RESPONSE TO H14-0585-26: Erection of implement store and welfare pod at Land north-west of the Chestnuts Glenside South.

Lincolnshire Wildlife Trust wishes to make the following comments on this application.

Post-Development Plan
Post-Development Map

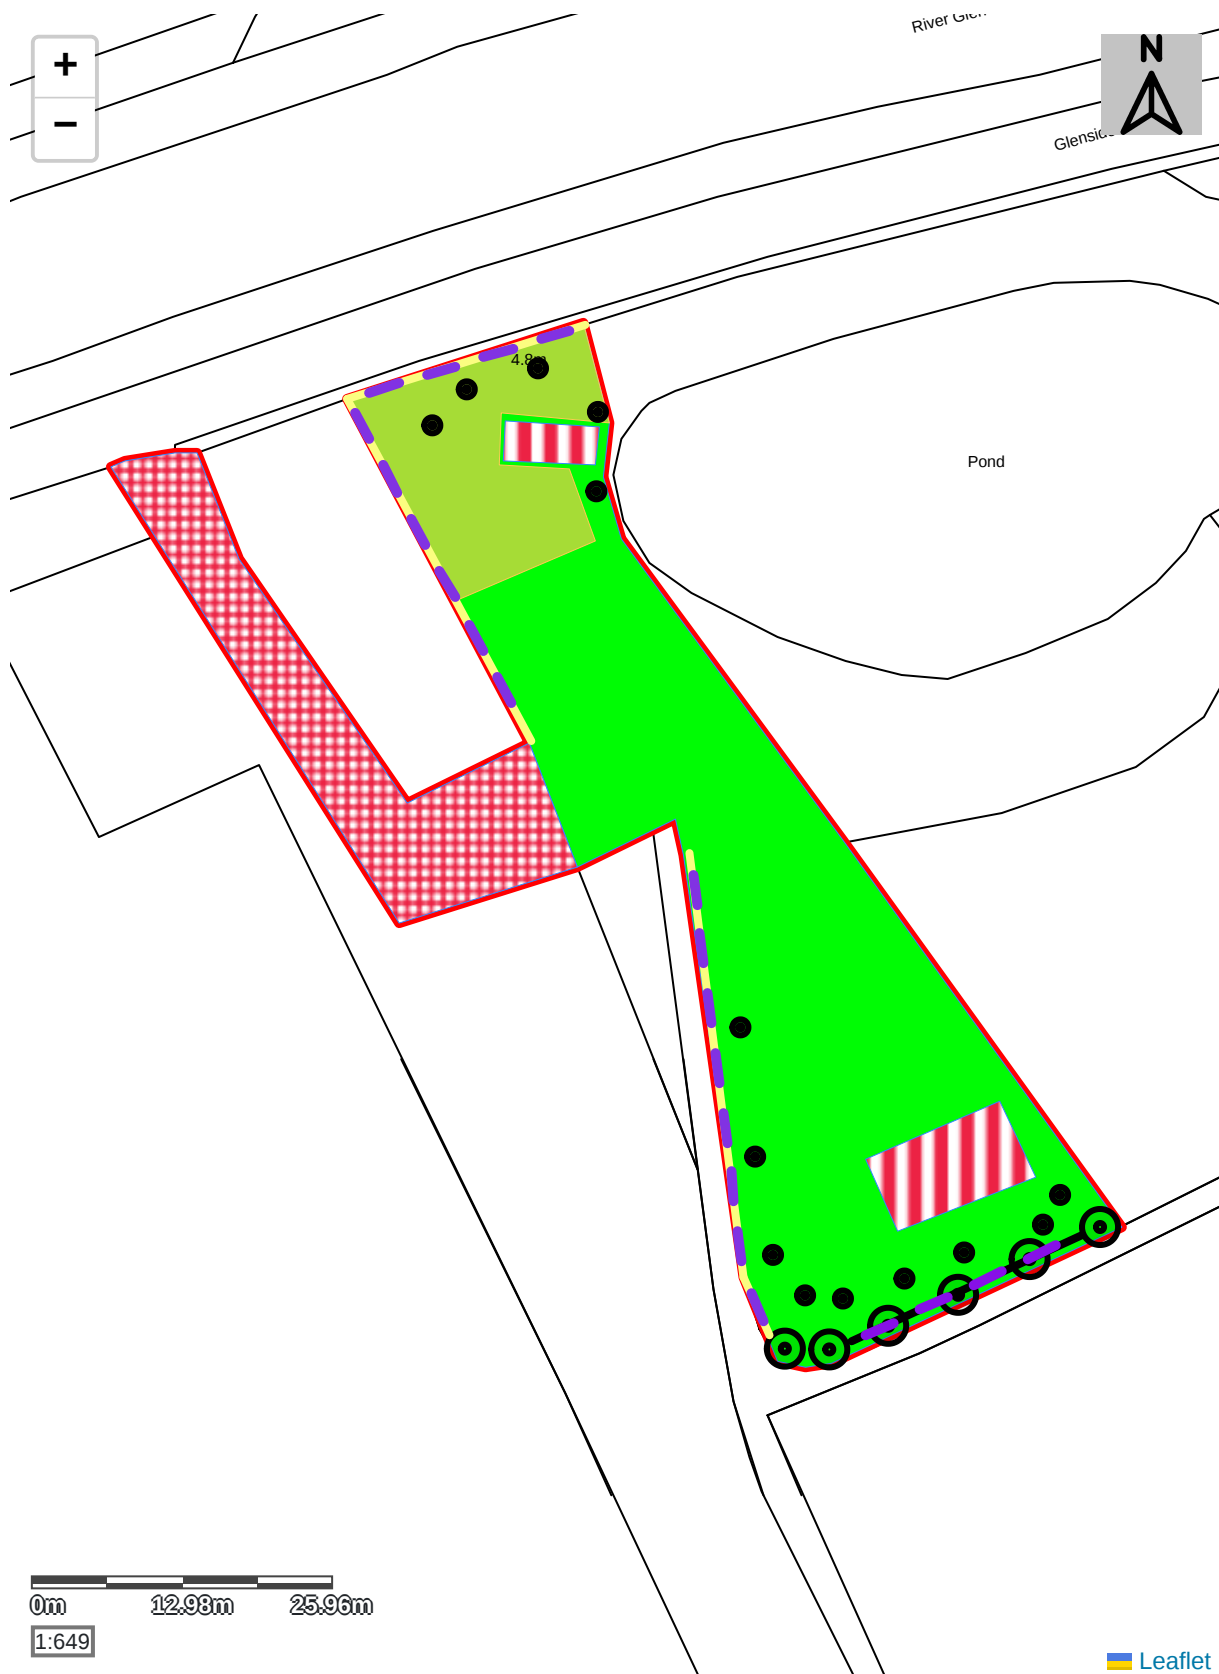
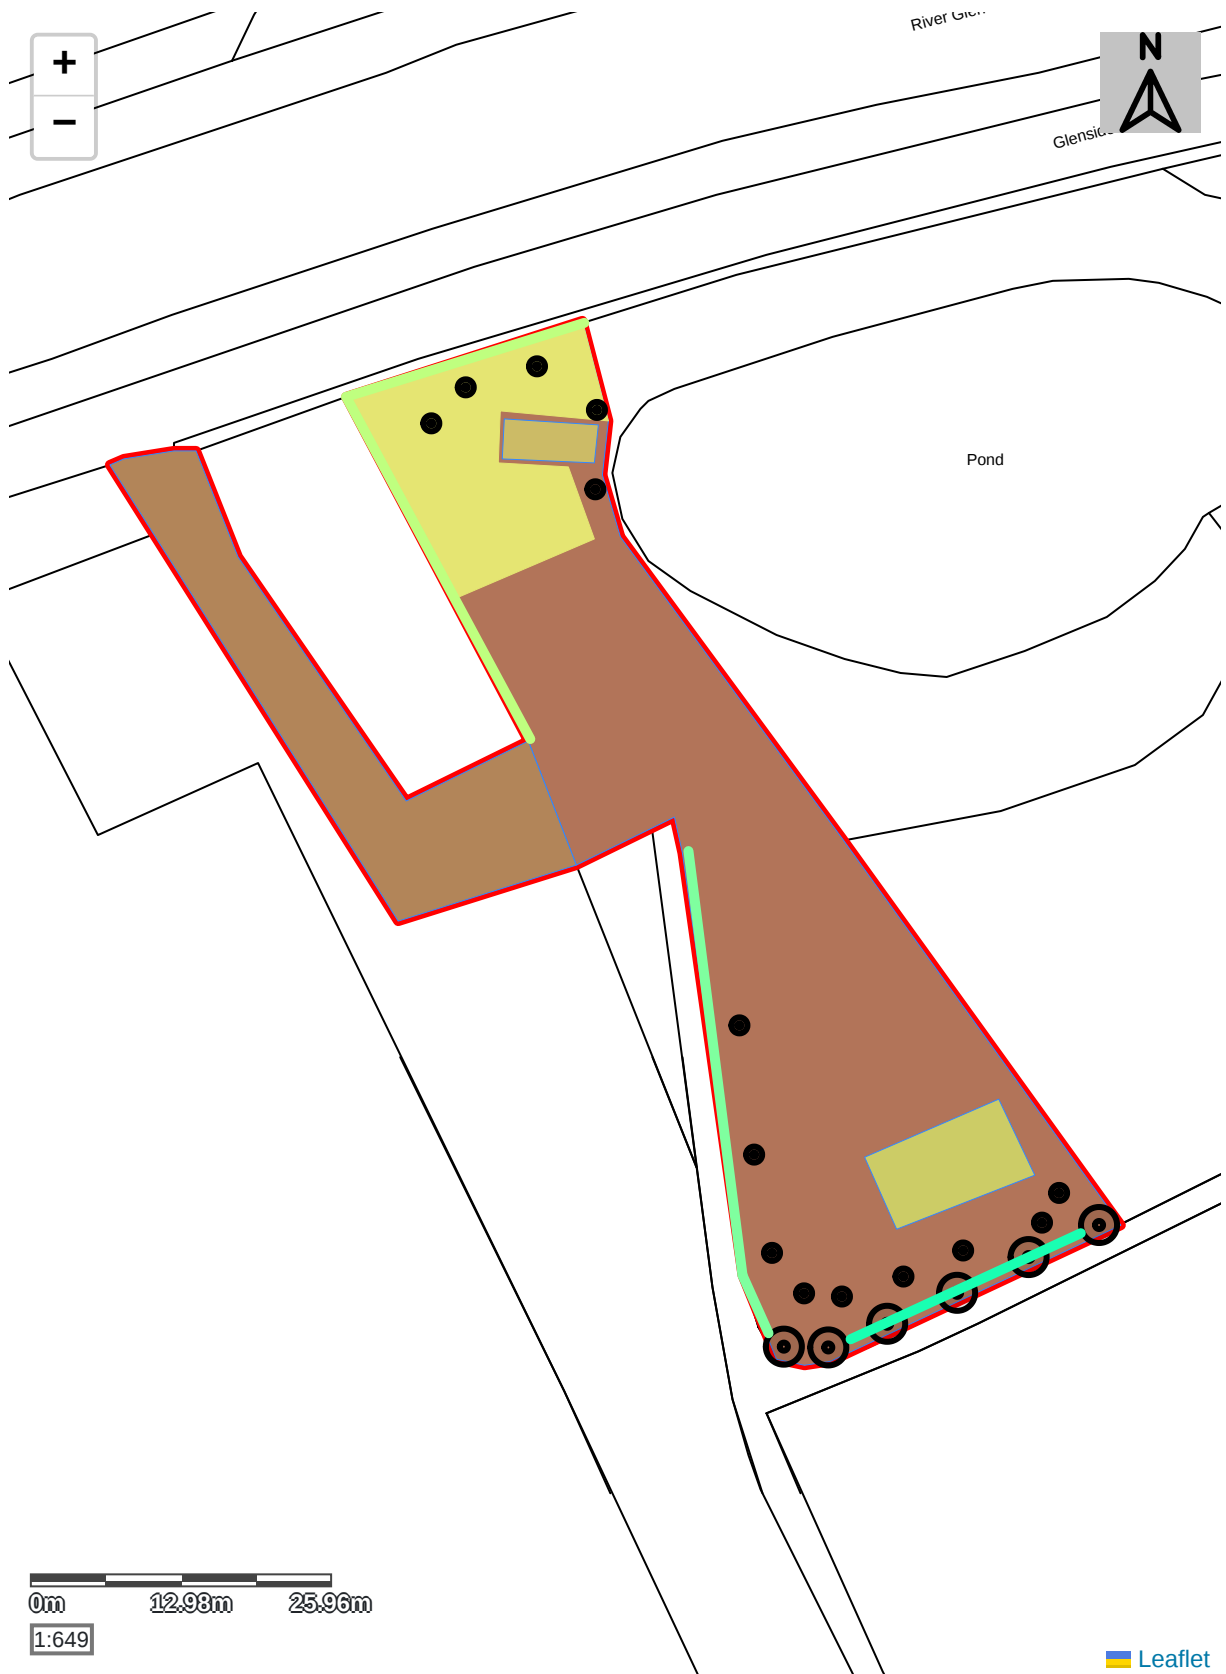
There has not currently been a preliminary ecological appraisal (PEA) conducted at the site. As it is directly adjacent to a pond, the priority habitat deciduous woodland, and the river Glen local wildlife site (LWS), a PEA should be conducted to assess the impact of the development on the adjacent habitats and potential protected species. The grassland is proposed to be enhanced to good condition, but this is likely to be an unrealistic goal unless further details can be provided as to how this will be managed for the 30-year period. Additionally, the proposed species-rich native hedgerow currently has only three species listed, but five are necessary to meet the requirements for this habitat. All planting should use species that are native and relevant for the area – for example, a native willow species such as goat willow (*Salix caprea*) should be used rather than the non-native contorted willow, and only planted in wetter areas near the pond. Native wild privet (*Ligustrum vulgare*) should be used in the hedgerow, rather than garden privet (*Ligustrum ovalifolium*).
